# Together Against Sizewell C

APPLICATION BY NNB GENERATION COMPANY (SZC) LIMITED  
FOR A DCO GRANTING CONSENT FOR THE SIZEWELL C PROJECT

## SUMMARY OBSERVATIONS & COMMENTS

### RELATING TO ISH 6: COASTAL GEOMORPHOLOGY

DRAWING TITLE:
PERMANENT COASTAL DEFENCE FEATURE
TYPICAL SECTIONS (MAIN)

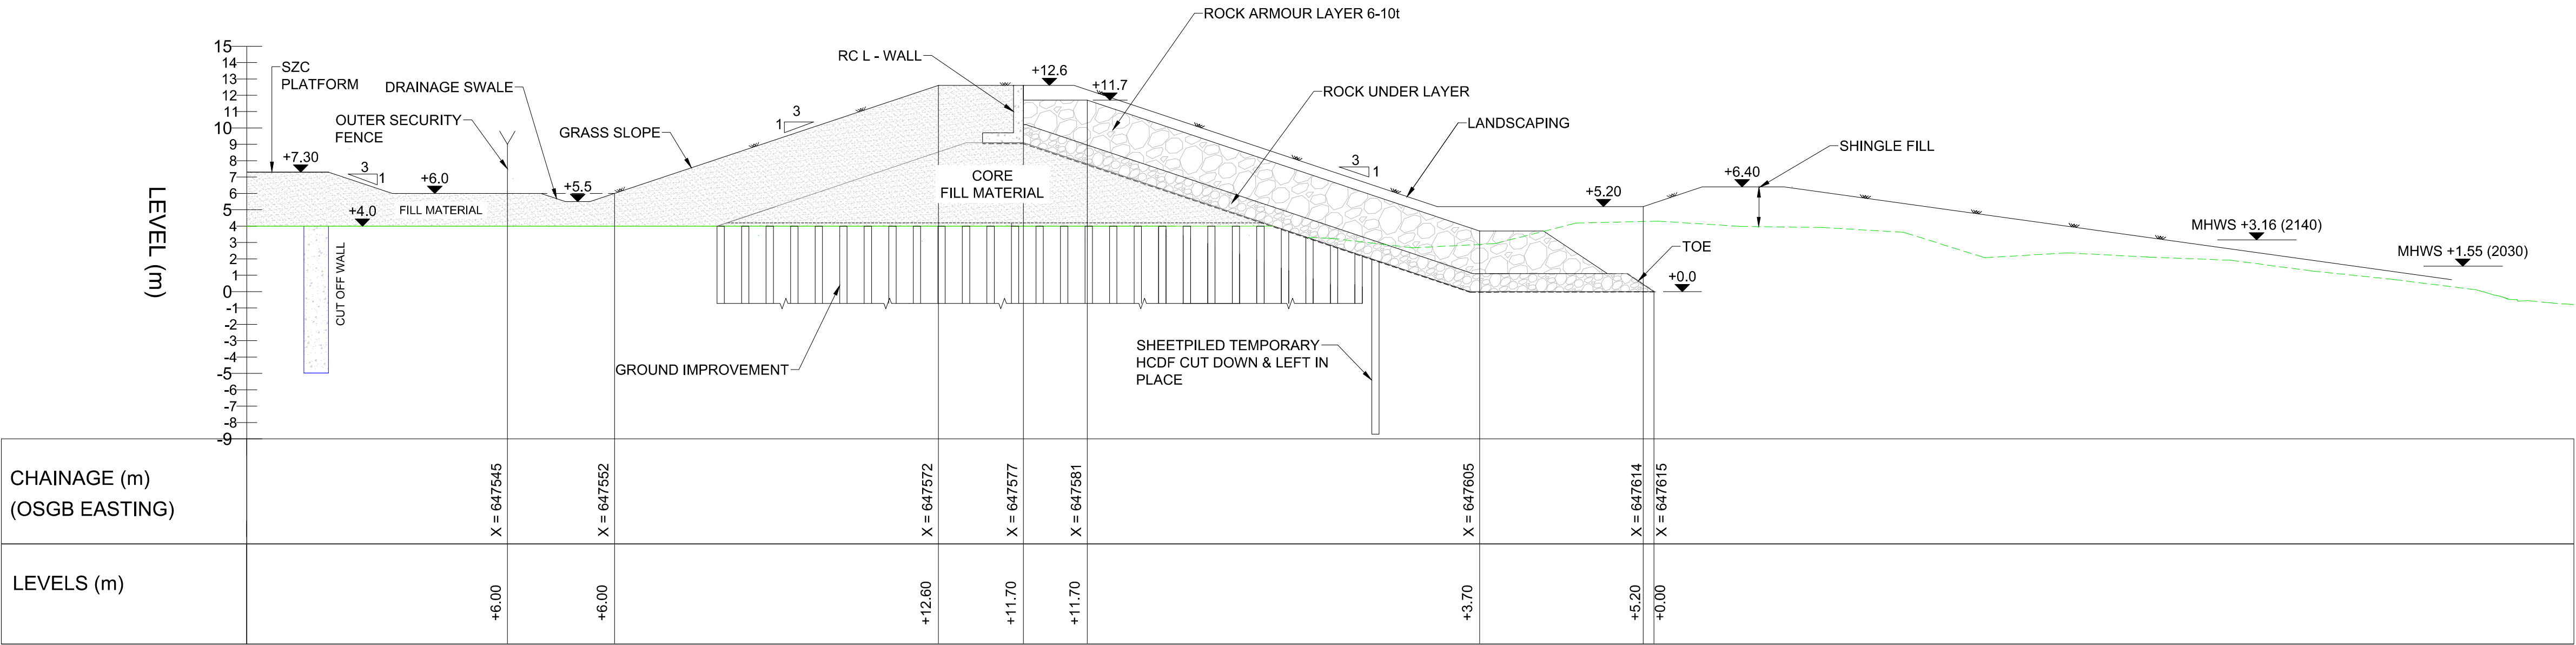
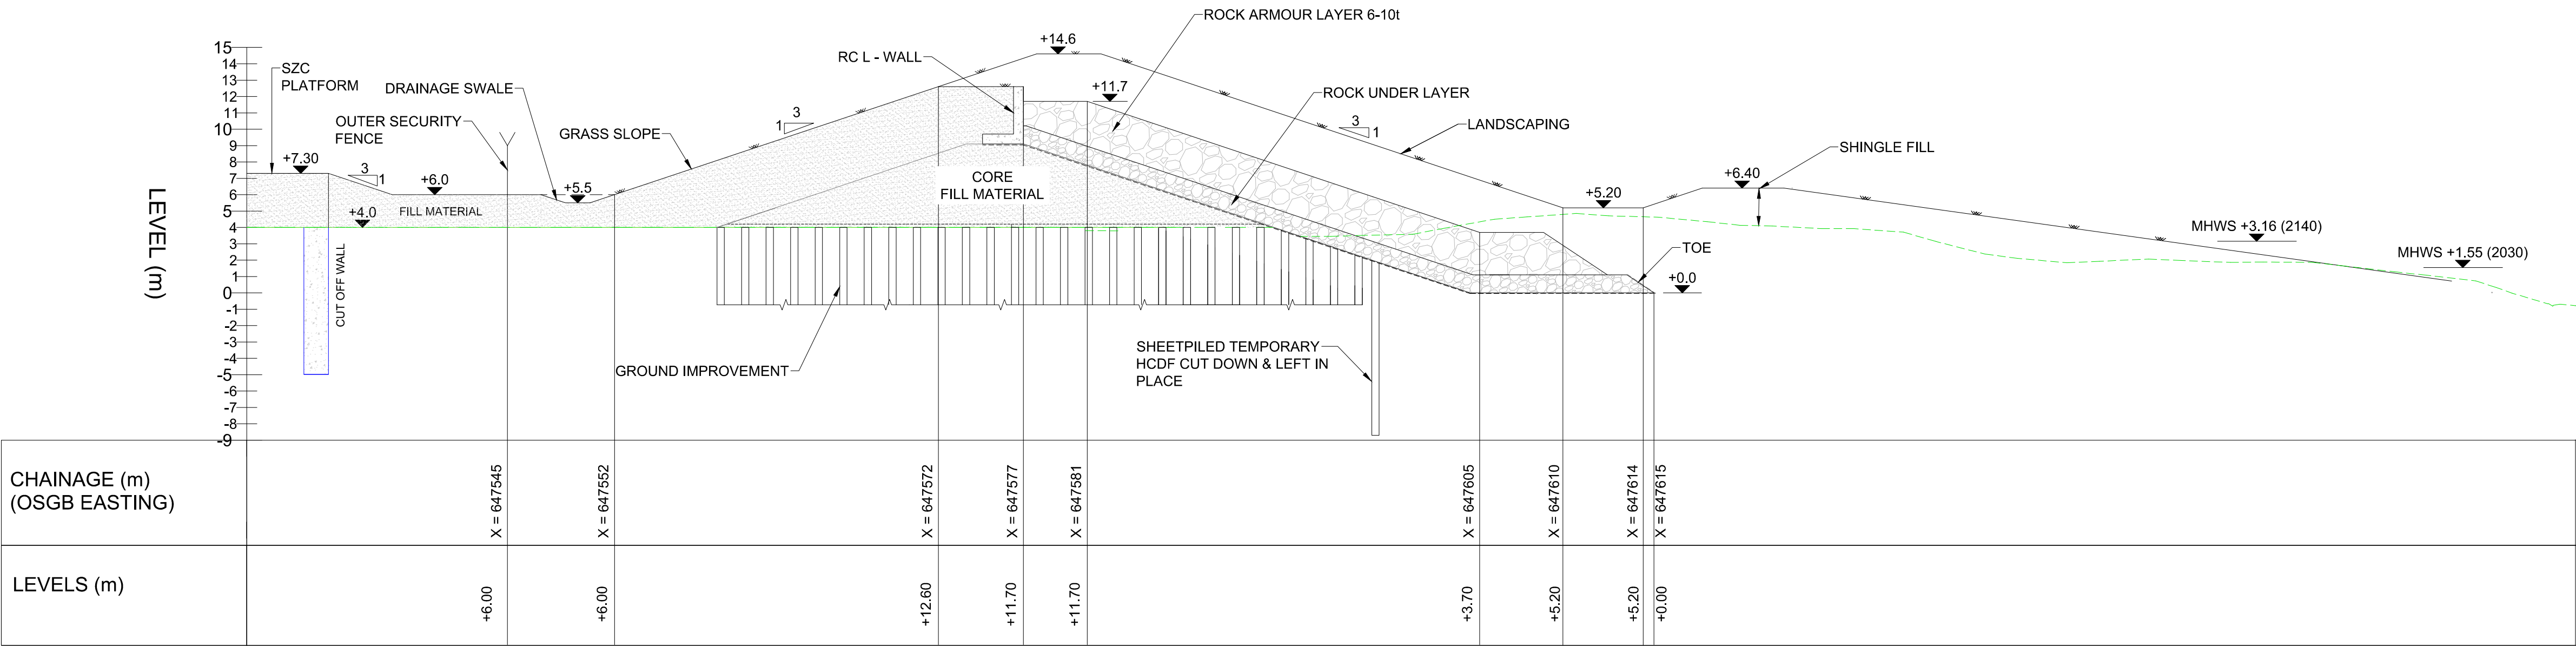
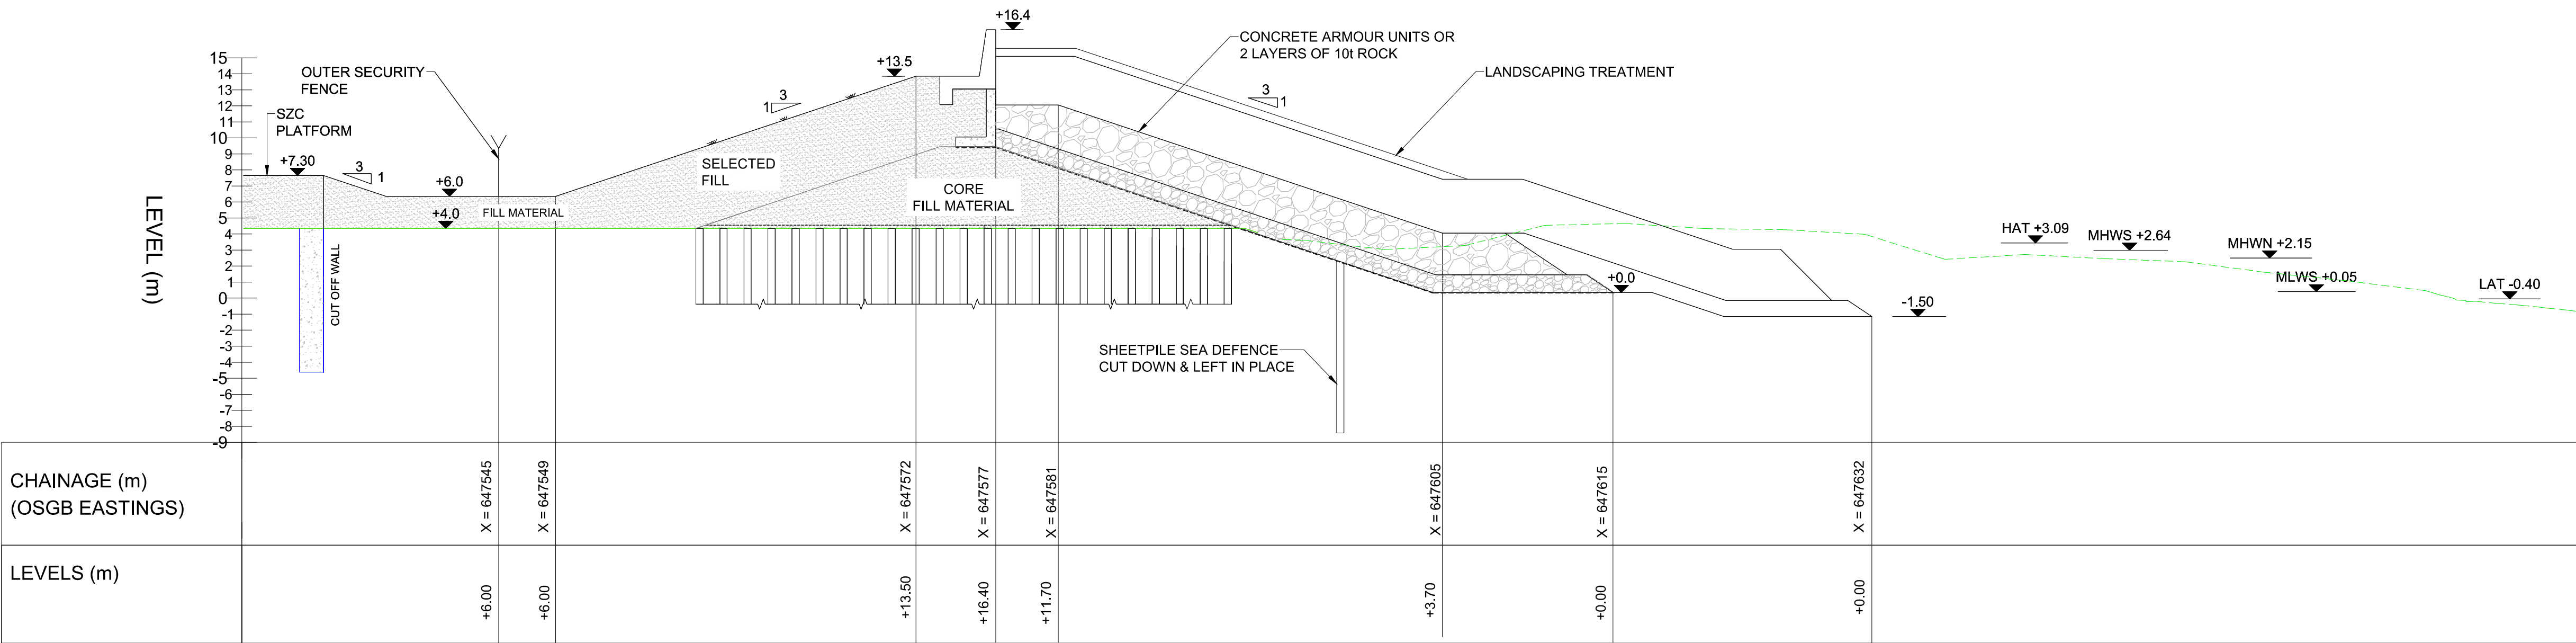
TASC have similar concerns to those expressed by various parties at this hearing including: how far seaward the proposed HCDF would be built; the seaward position and risk to the toe being undermined by the sea; concerns that non-native materials may be used in the sea defences (we reference here the large geotextile sandbags used as part of the sea defences, which were installed at Thorpeness between 2008 and 2010 and which can now be found strewn up and down the Suffolk coastline); the scale of construction (including the impact on the AONB and Heritage Coast) and potential impacts on coastal processes in the event that the height of the sea defences needs to be raised in line with the adaptive design involving the toe being moved up to 17 metres towards a rising sea level; the apparent lack of assessment relating to the construction of the HCDF on soft (peat) ground. Surely, if the Applicant is planning to proceed on the basis that a vast soft coast sea defence feature will be lost to the sea, exposing the imposing concrete structure that is the HCDF, it must call into question the viability and vulnerability of the entire site and the SZC proposals.
